**KIRKLEES METROPOLITAN COUNCIL
INVESTMENT & REGENERATION SERVICE**

DELEGATED DECISION TO DETERMINE PLANNING APPLICATIONS

Reference No:	2026/62/90818/W
Site Address:	adj, Ash House, 240, Dunford Road, Holmfirth, HD9 2SJ
Description:	Erection of detached dwelling
Recommending Officer:	Joanna Rednall

DECISION - REFUSE

C/No. 767060	D/No.	SCALE 1:500 @A2
DRAWN JP	DRAWING NUMBER BP02	
DATE 21/11/25	REV A

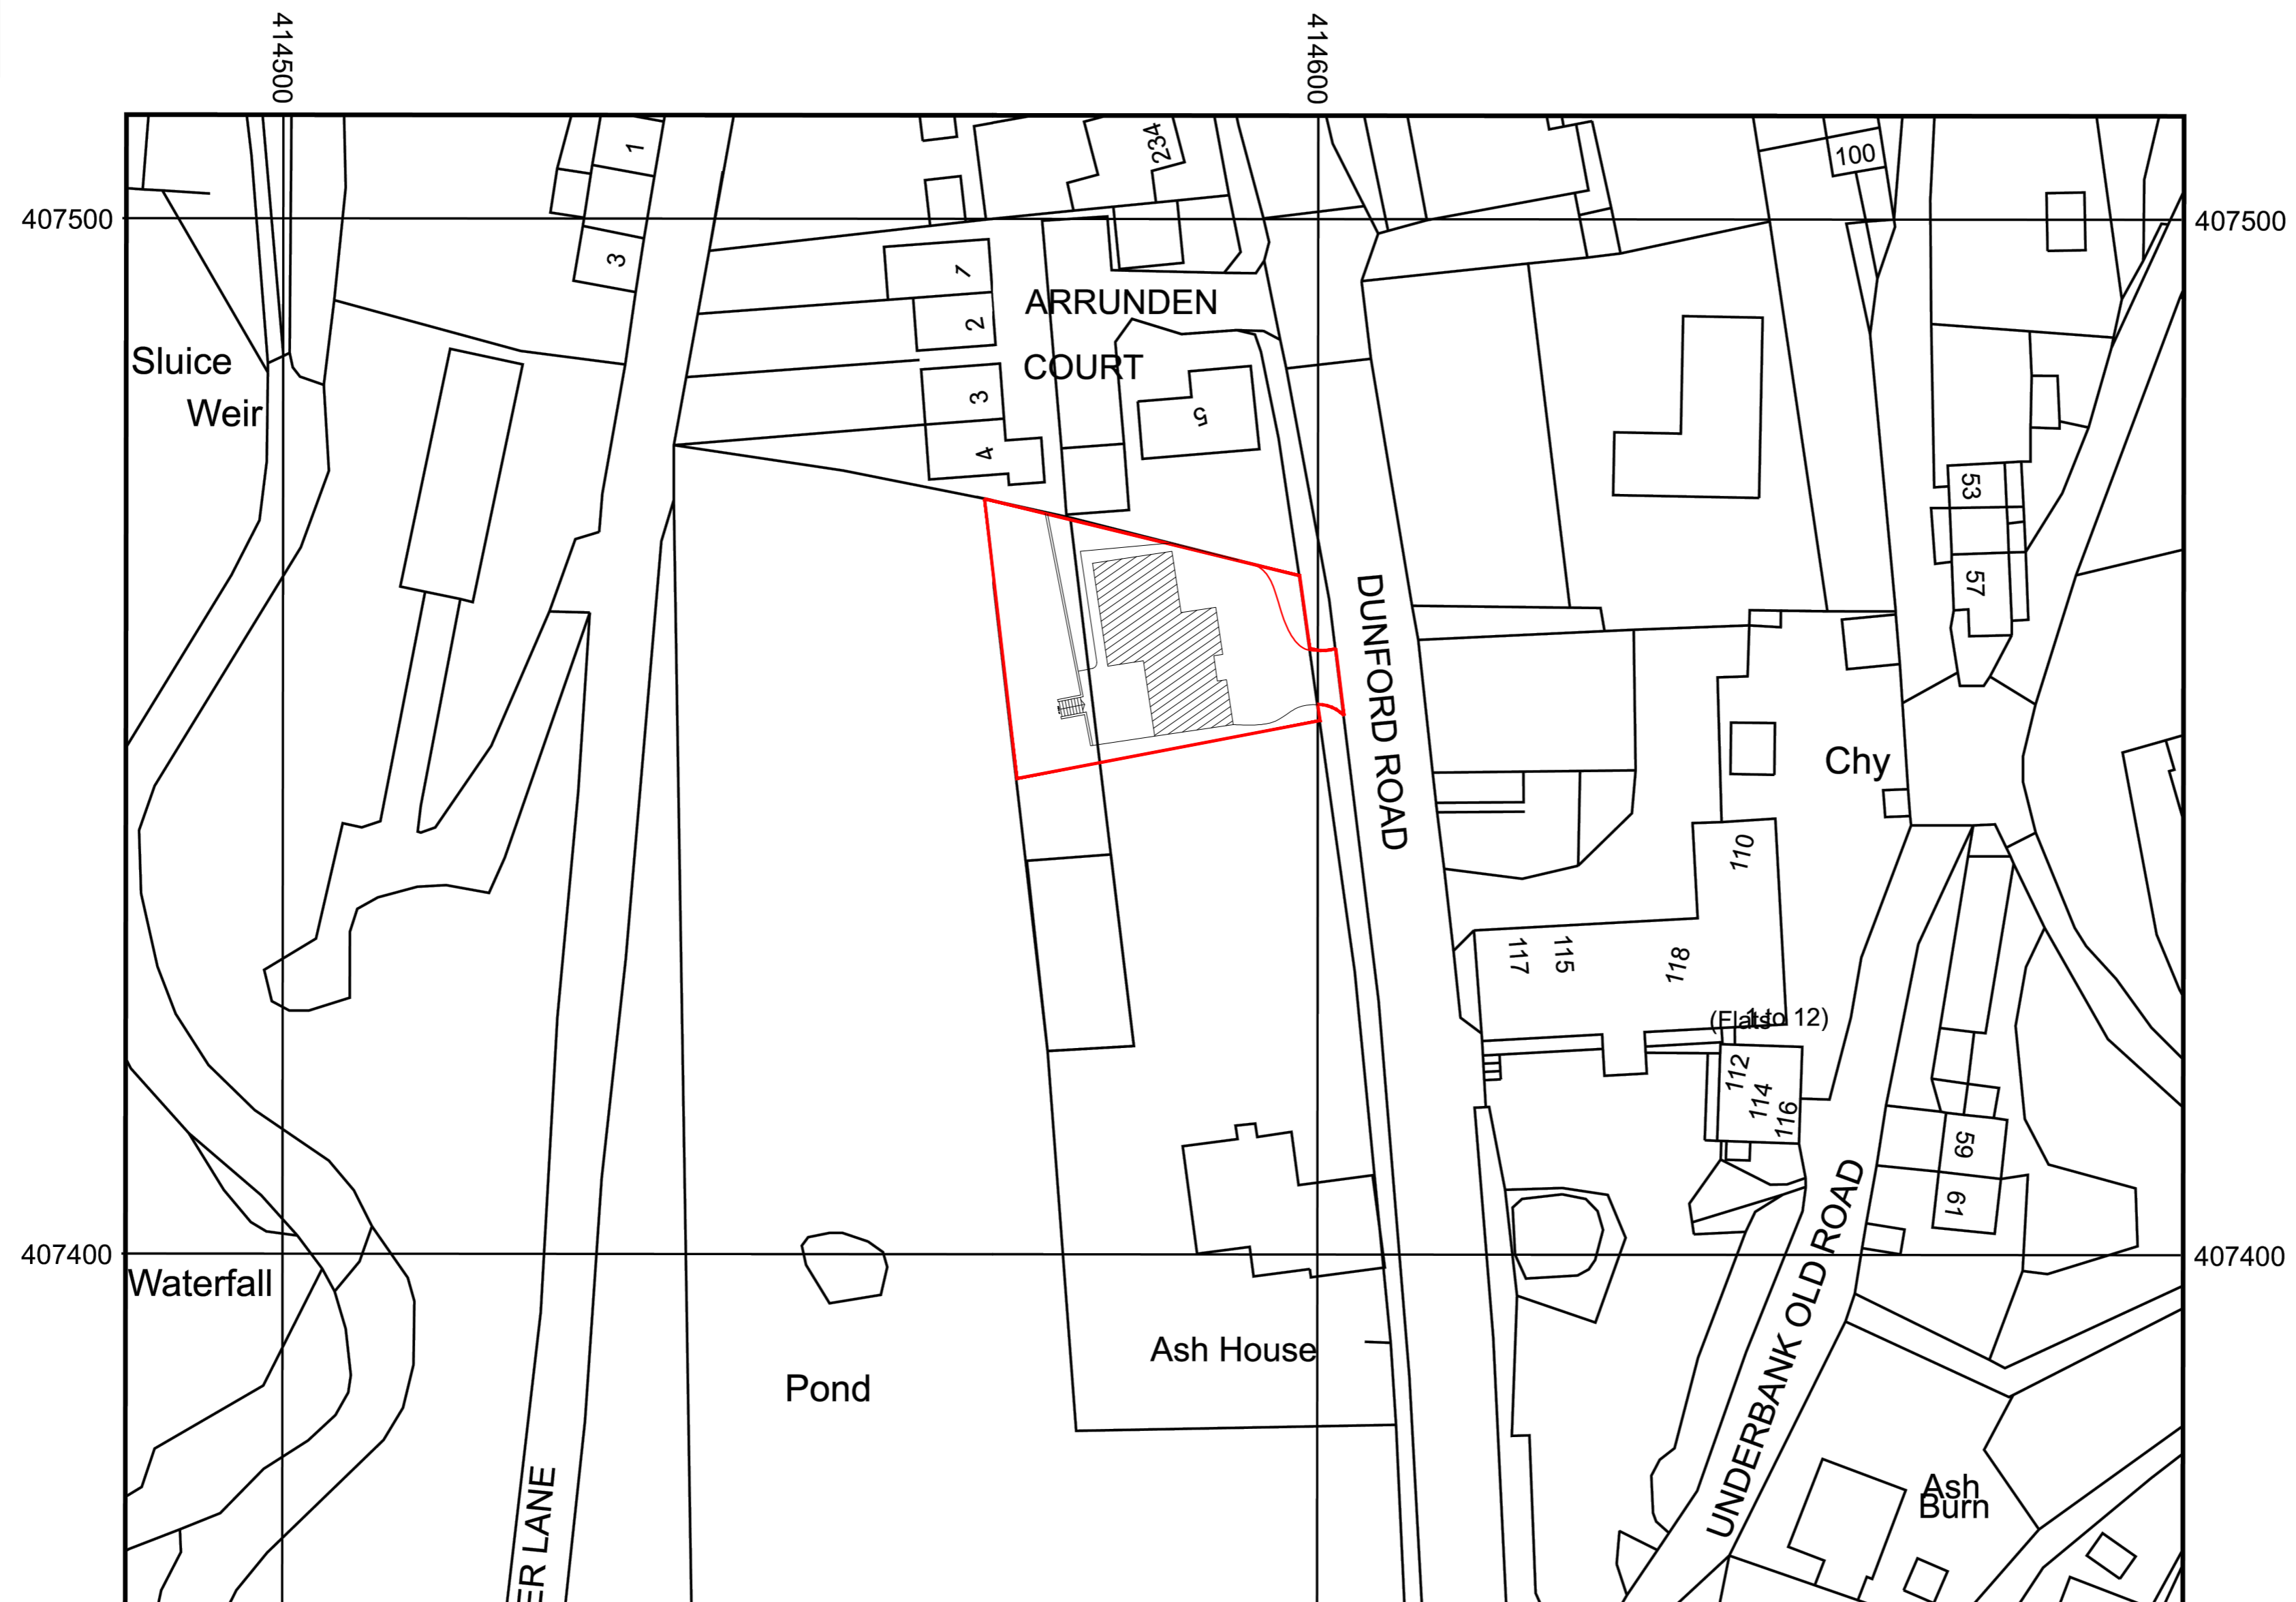
The development would extend built form along the main highway, reading as a continuation of ribbon development. This linear expansion would have a noticeably urbanising effect on this part of the Green Belt frontage, eroding the currently open and transitional character that contributes positively to the setting.

Although there is no rigidly defined building line, the dwelling would sit broadly in line with Ash House to the south, albeit marginally set back. Nevertheless, its siting and massing would reinforce the perception of a continuous built

Ash House is a two-storey semi-detached dwelling situated to the south of the application site. The proposed site plan indicates a separation distance of approximately 38m between the side elevation of the new dwelling and the front elevation of Ash House.

FRONT ELEVATION – EAST

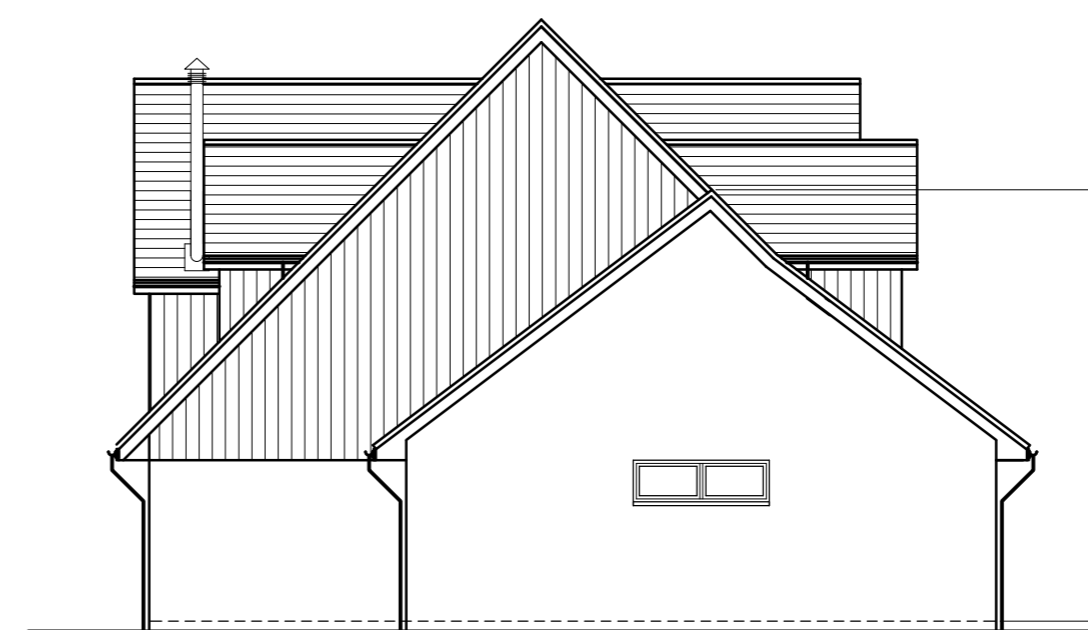
The proposed dwelling adopts a contemporary architectural approach, incorporating a dual-pitched roof with elevations finished in render and composite timber cladding. Large areas of glazing are proposed to the rear, with tall, narrow openings to the front elevation reinforcing the modern aesthetic. While the immediate street scene contains some variation in scale and form, the prevailing character is defined by a traditional material palette of stone walls and slate roofs. This consistency forms an important part of the area's identity.

The introduction of a contemporary palette, particularly the composite cladding and extensive glazing, would appear discordant within this context. It would not reflect the established vernacular or the locally distinctive use of natural stone, contrary to Policy LP24 of the Kirklees Local Plan, Principle 2 of the Housebuilders Design Guide SPD, and the design expectations of Chapter 12 of the NPPF.

While the pitched roof form and proposed grey slate finish would broadly reflect neighbouring rooflines, this does not mitigate the wider concerns. The combination of modern cladding materials and extensive glazing would remain at odds with the established character, resulting in a development that fails to integrate sensitively with its surroundings. This conflicts with the design principles set out in Policy LP24(a) and Policy 2 of the Holme Valley Neighbourhood Plan, which require new development to respect local grain, materials, scale and form.

GROUND FLOOR PLAN

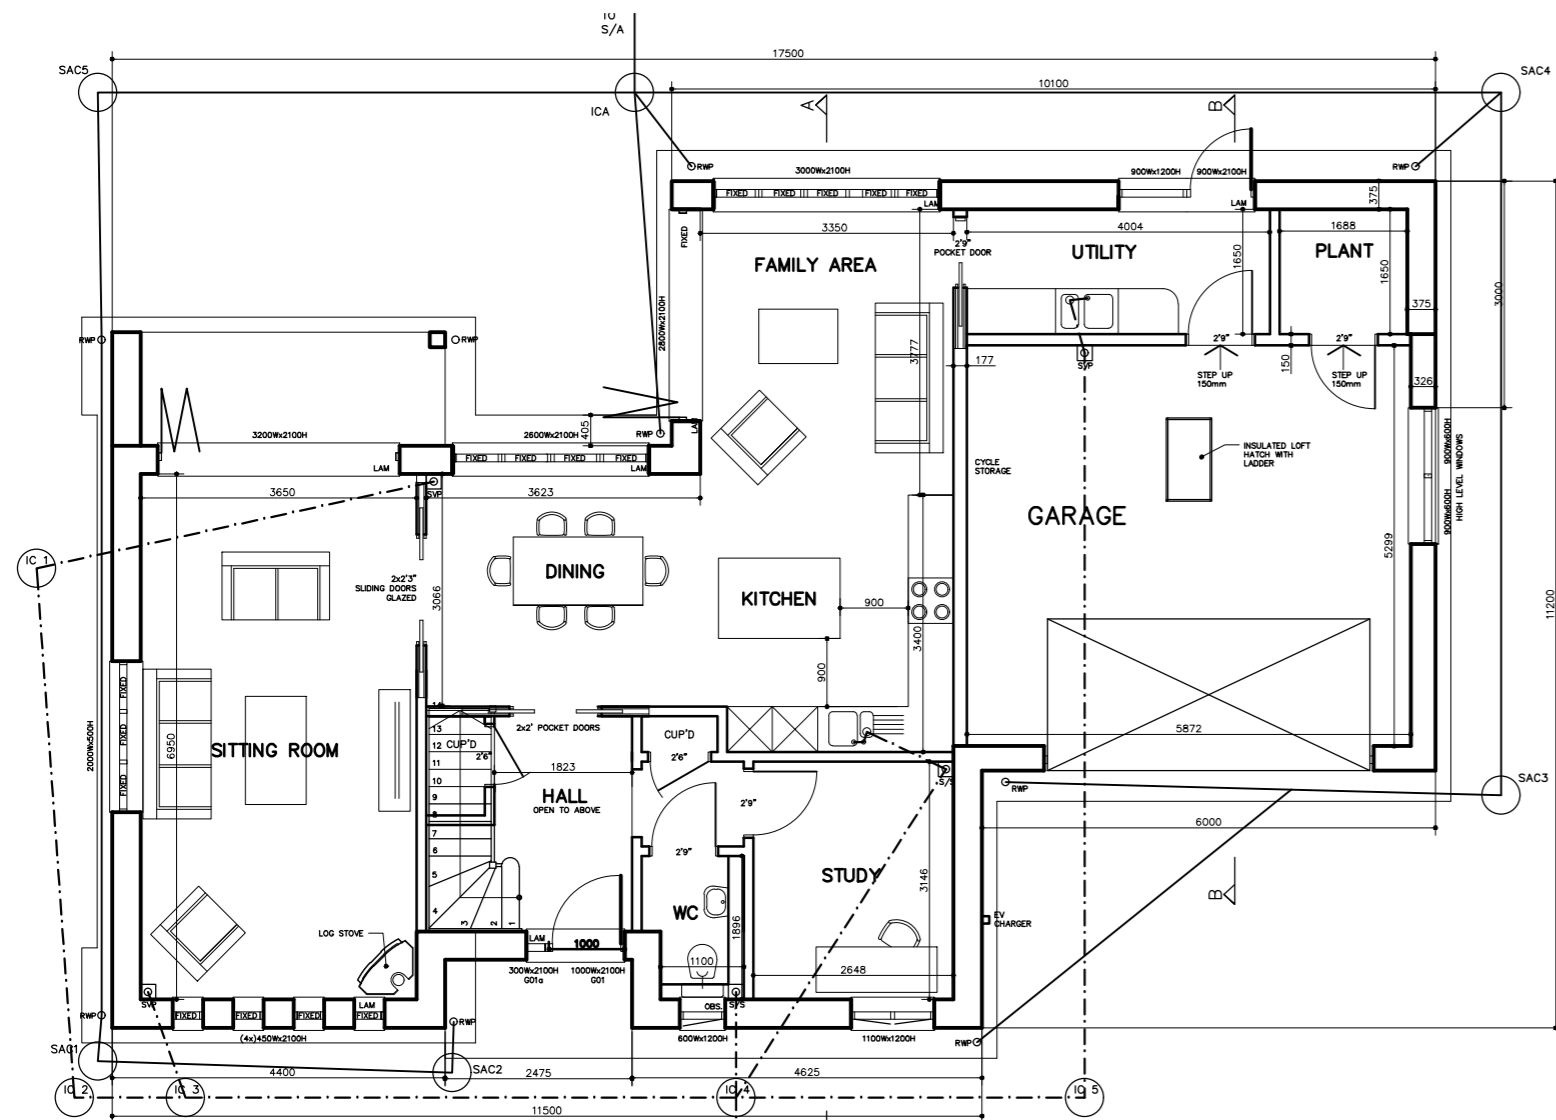
In terms of overlooking, the submitted floor plans confirm that no habitable-room windows would face towards No.5. A single ground-floor window is proposed on the relevant elevation; however, this serves a garage and would face directly onto boundary treatments. Given its ground-floor position and non-habitable use, the window would not give rise to overlooking or loss of privacy. The proposal is therefore considered acceptable in this regard.

The proposal includes a double garage together with turning and parking space to the front of the dwelling. Under the Kirklees Highways Design Guide SPD, a minimum of two on-site parking spaces is required for dwellings containing 2–3 bedrooms. The scheme therefore provides sufficient off-street parking provision for a three-bedroom property.
